PROJECT NAME: Gibson Mobile Home / File No. C18-7
SUBMITTAL DATE: 12/31/18
SUBMITTED BY: Elizabeth Gibson, Dan Raw, Jennifer Shoemaker
SUBMITTAL REVIEWED BY: _____

Re: File No. C18-7
Subject Property: 8240 Piute Rd.

File No. C18-7: Attachment A

File No. C18-7: Attachment A

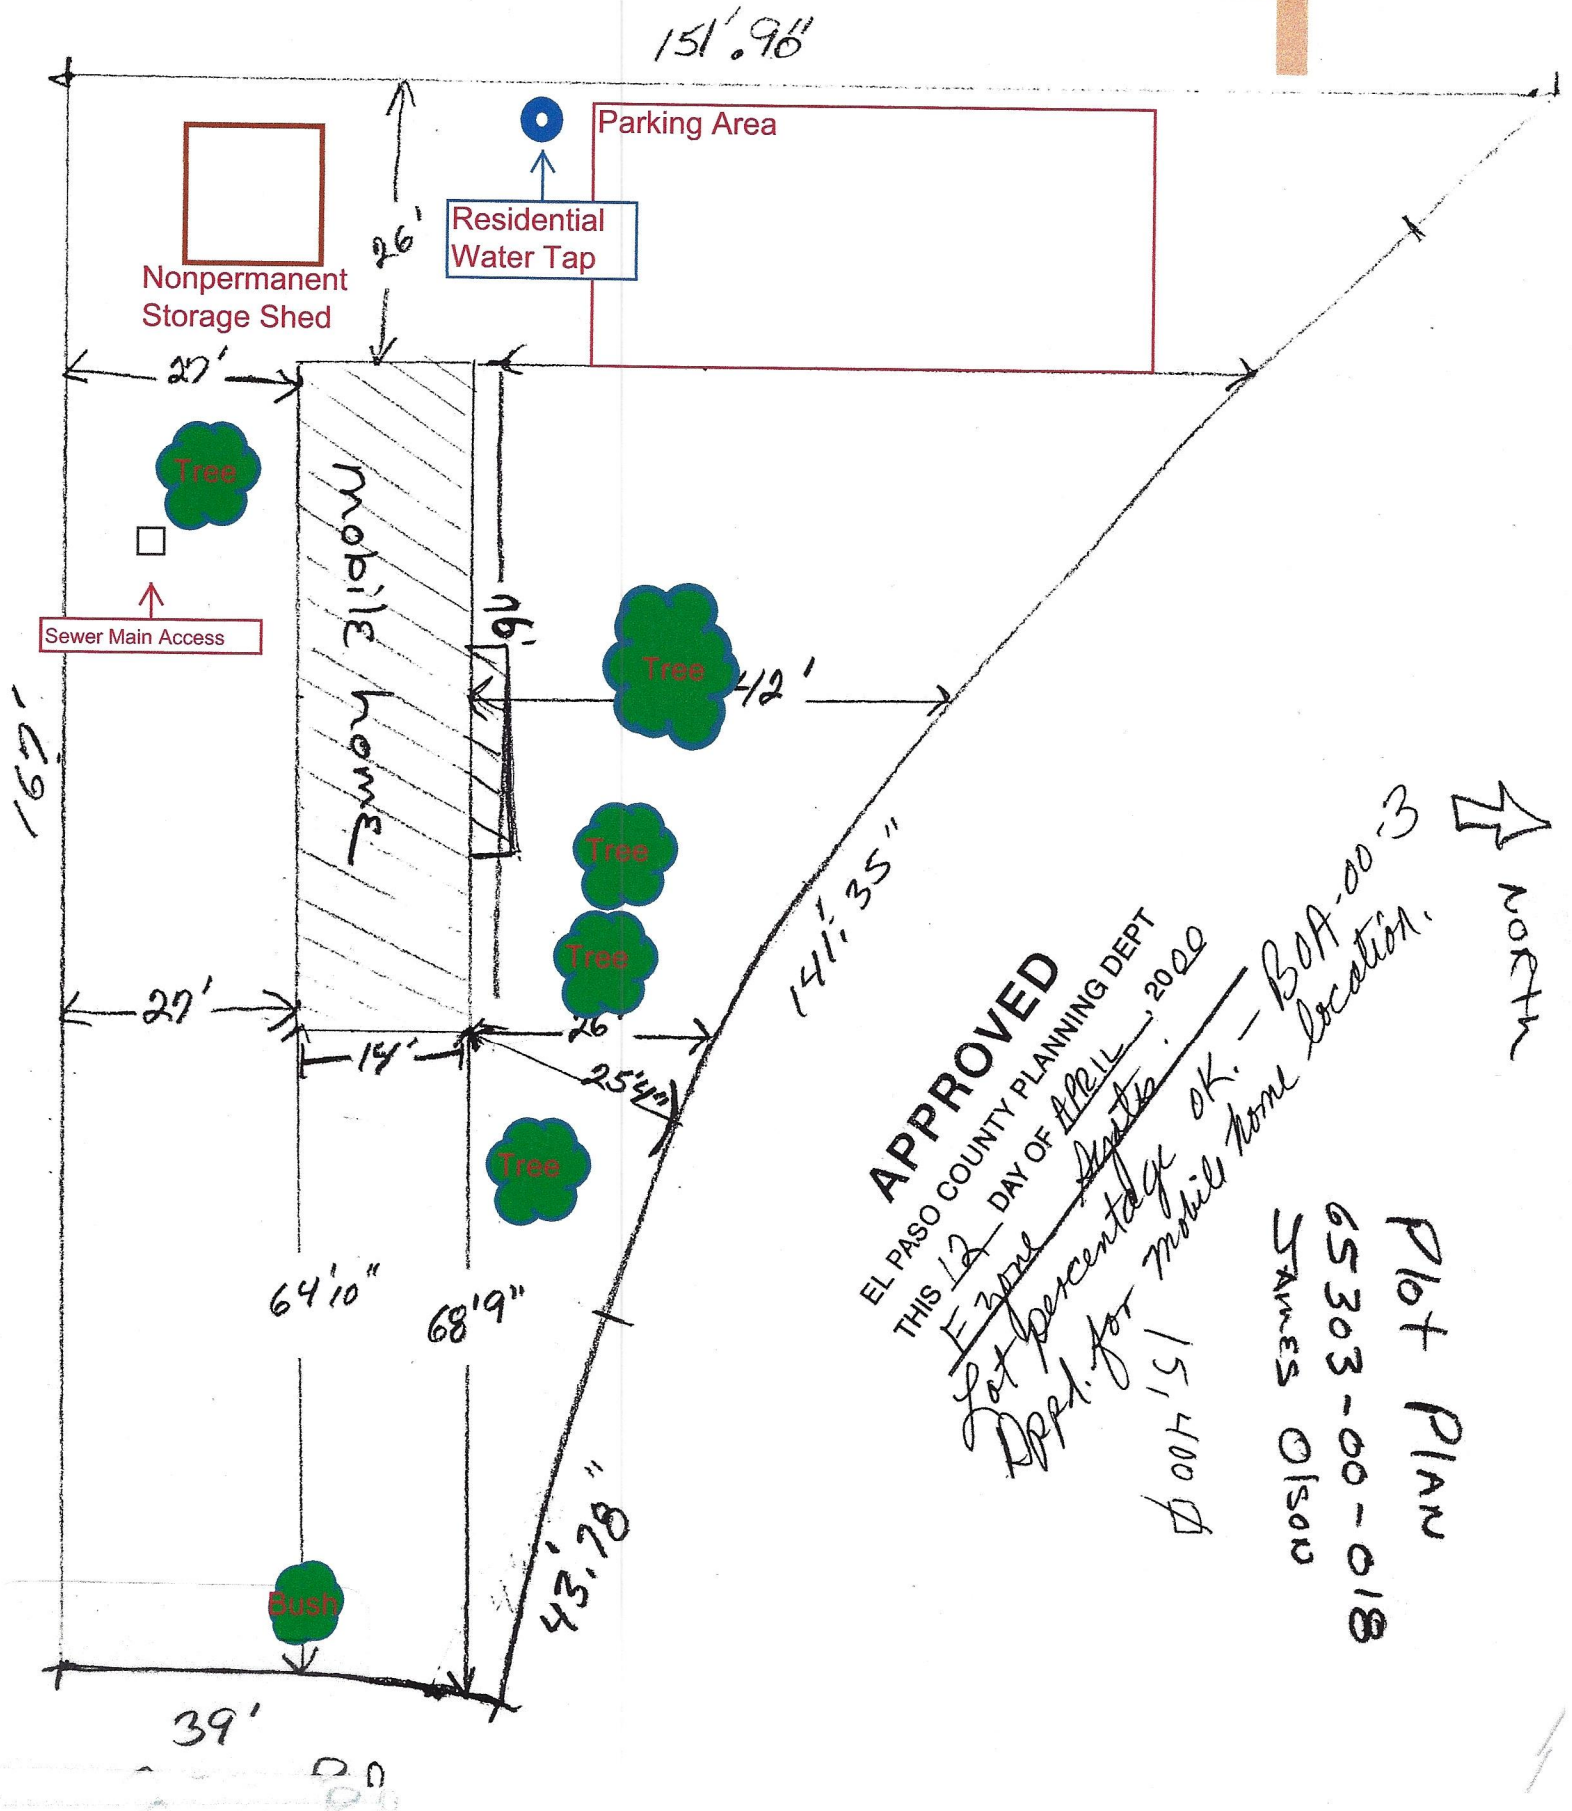
This is not Lot 18. Please remove.

Remove this statement. The property has the ability to access off of Piute Road.

Project file number for this submittal is VA191. Please revise.

This needs to meet the 25 foot setback, it needs to be moved or have a dimensional variance Board of Adjustment hearing.

If this is an El Paso County Easement, please provide the documentation to verify this. If this is not an El Paso County Easement, please label as private easement. A recorded easement may need to be obtained. Will confirm this with the County Attorney.

Remove this approval stamp

If these lines are the property boundary, please identify as such.

Remove James Olson's name from the plan.
